File Ref. No: BFS16/2629 (12179)
TRIM Doc. No: D16/90974
Contact: Daire Fleming

15 December 2016

**Walsh Bay Arts Precinct Stage 2
Hickson Road, Dawes Point (SSD 7689)**

I refer to the above development proposal's Environmental Impact Statement (EIS) which is currently on public exhibition. Fire & Rescue NSW (FRNSW) has reviewed the following specific documents that are attached to the EIS exhibition:

The proposed compartmentation strategy is outlined below in the following figures:

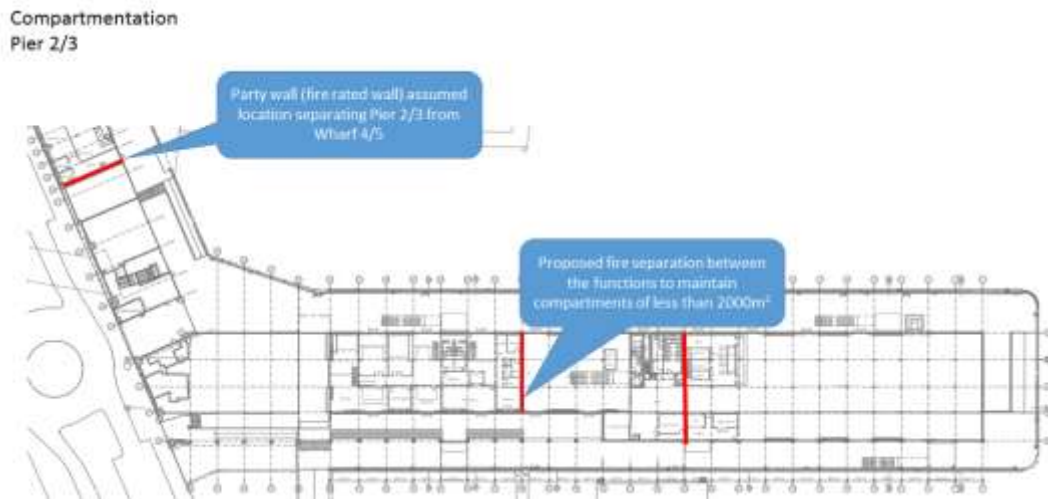
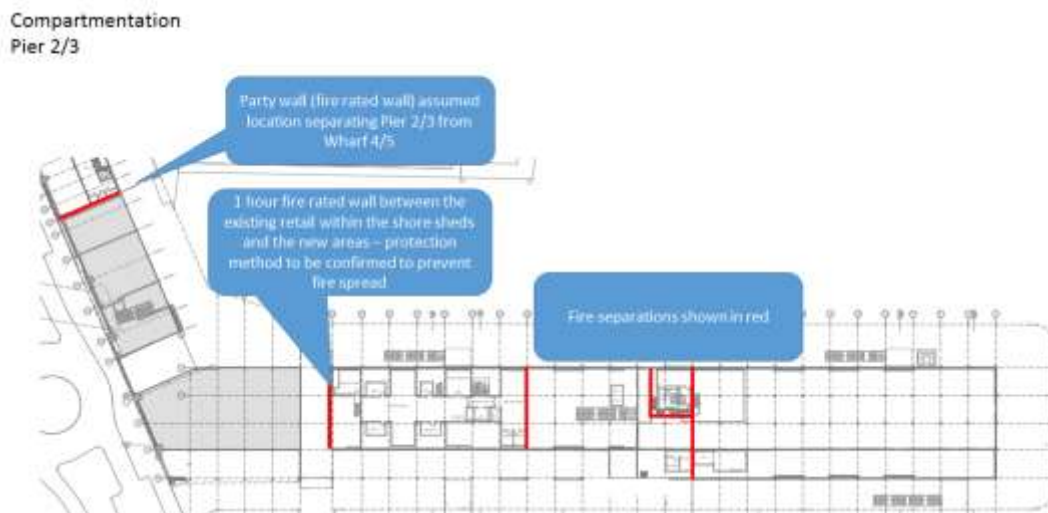
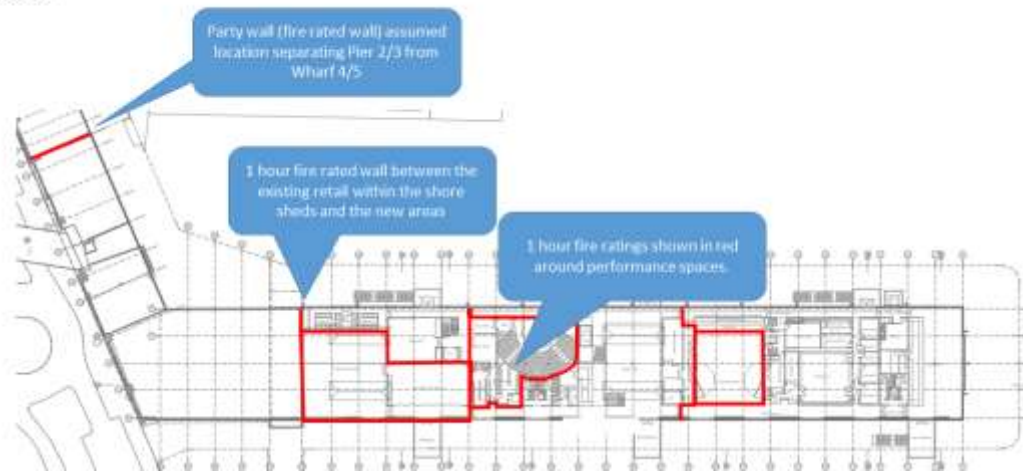
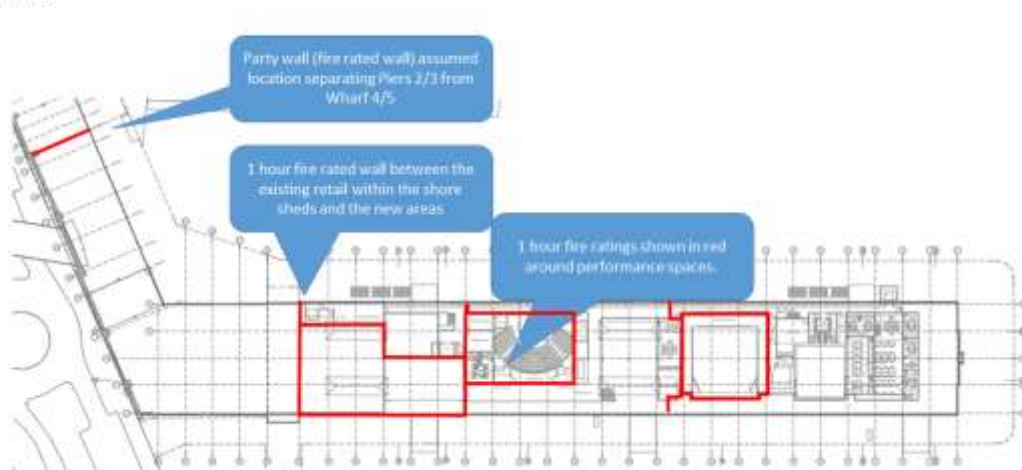
1. That the maximum compartment size is to be maintained within 2000m² floor area to limit the risk to occupants and fire fighters in the event of an emergency. FRNSW recommend that adequate compliant separation be provided between compartments to limit fire/smoke spread throughout the development and that new compartment walls shall comply with minimum requirements of the NCC. Limiting the compartment sizes will provide a sufficient period of time to afford first responders with an opportunity to protect property on arrival.

Figure 20: Pier 2/3 Level Ground Floor

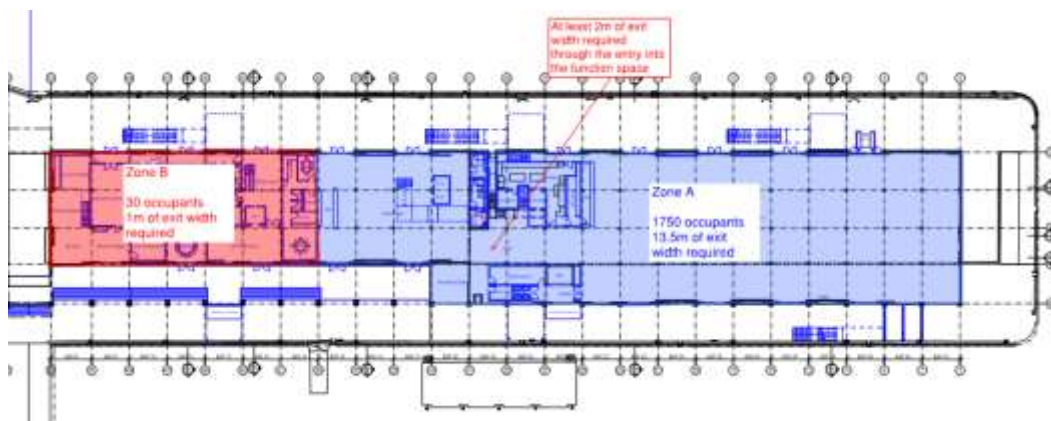
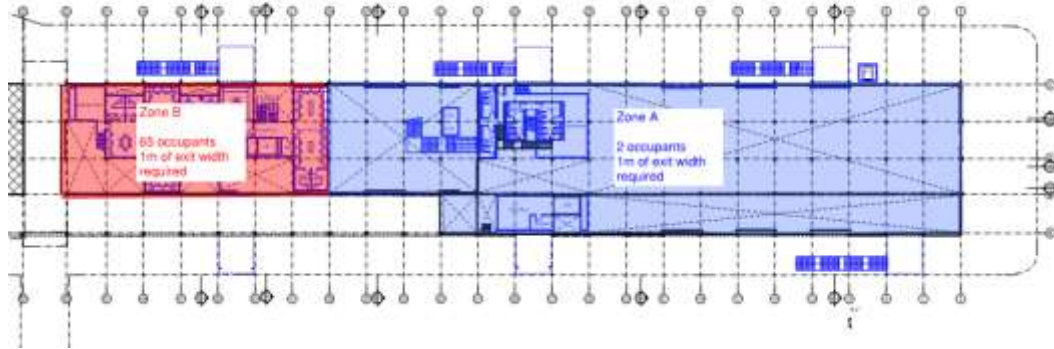
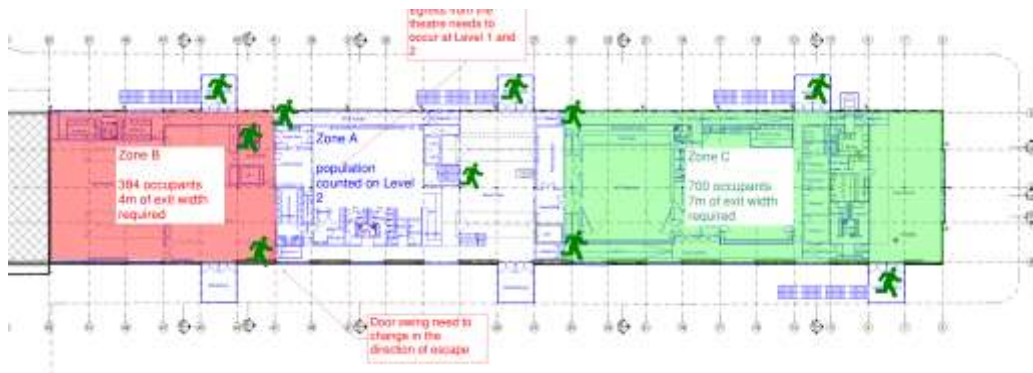
6. That adequate justification is provided for proposing a 4-6 minute staging evacuation delay between zones for the subject development as outlined on page 17 of the FER for SSDA. This delay may have major egress and fire brigade intervention ramifications in the event of arson or a terrorist attack.
